Application number: 2018/93963	
What is the application for?:	Erection of two storey rear extension
Address of the site or building:	21, Oakland Court, Highburton, Huddersfield, HD8 0XF
Postcode:	HD8 0XF

Type of comment: An objection
<p>I would like to object to the above application and have the following observations:</p> <p>Impact on visual amenity</p> <p>BE1 requires development to respect local character and be visually attractive. BE2 and BE13 requires new development to be in keeping with existing development, including materials, scale and massing. BE14 states that, typically, rear extensions will be limited to an extension of 3.0m.</p> <p>The extension projects 2.4m, so is considered acceptable in principle in respect. However, the proposed addition is hard up against the common boundary with the attached dwelling . The proposed development has eaves which would match the host building. However, the roof ridge is set down a nominal distance from the height of the roof ridge of the original dwelling (as opposed to being lower, so as to appear subservient).</p> <p>The scale and massing of the extension is considered too great and harms the visual character of the building,

NUMBER
3151/3

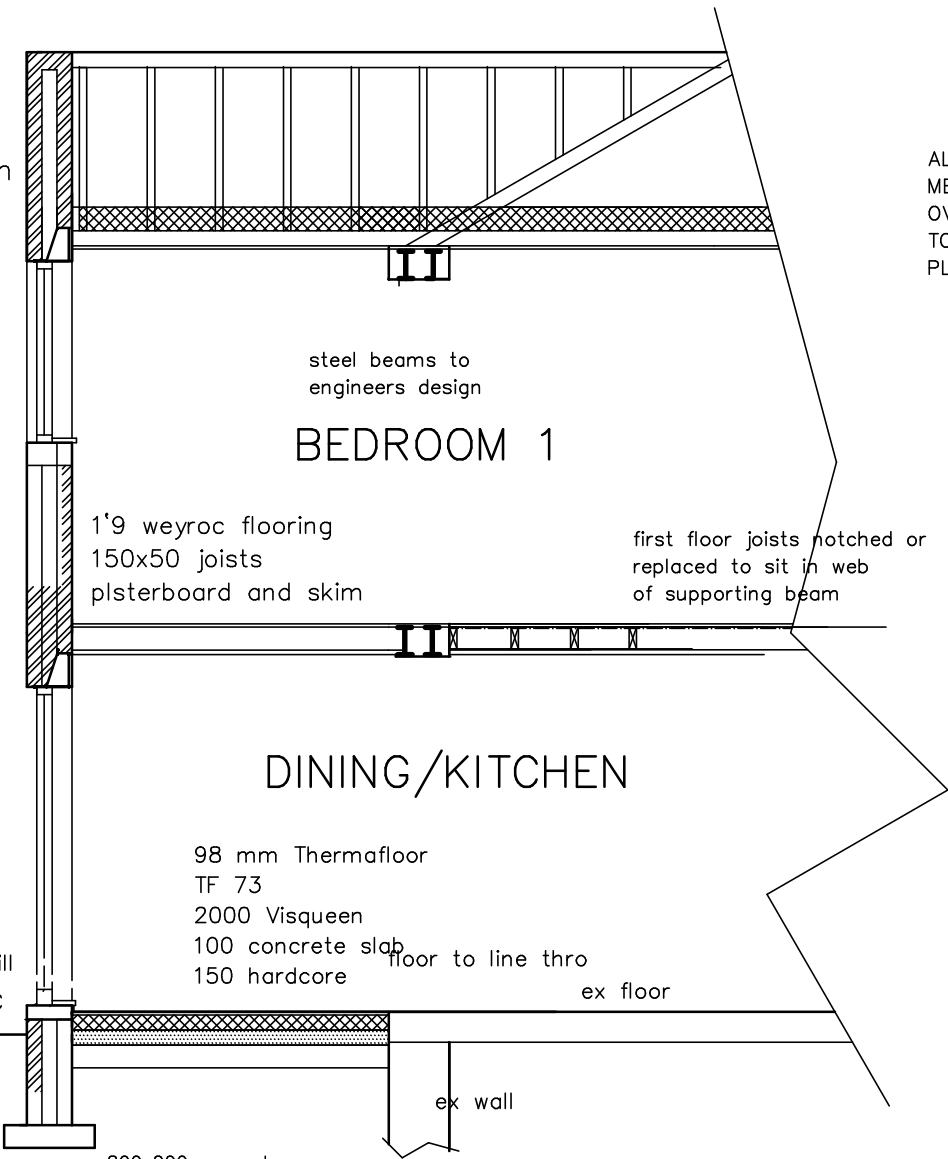
The extension is to be two storeys, and would project 2.4m along the shared boundary at n Oakland Court. This size and mass would cause significantly harmful overbearing and overshadowing

This distance would be reduced to 17.6m by virtue of the proposed development. This reduced separation distance would have a significantly harmful impact on the amenity that the residents of Southfield Court have the right to enjoy.

While a condition could be imposed requiring the windows to be obscure glazed, it is not ordinarily considered acceptable to have a bedroom without some form of clear glazed opening and in any case the scale of the window would be so large as to give an impression of overlooking even with obscure glazing in place. The proposed development would cause harmful overlooking and overbearing of Southfield Court.
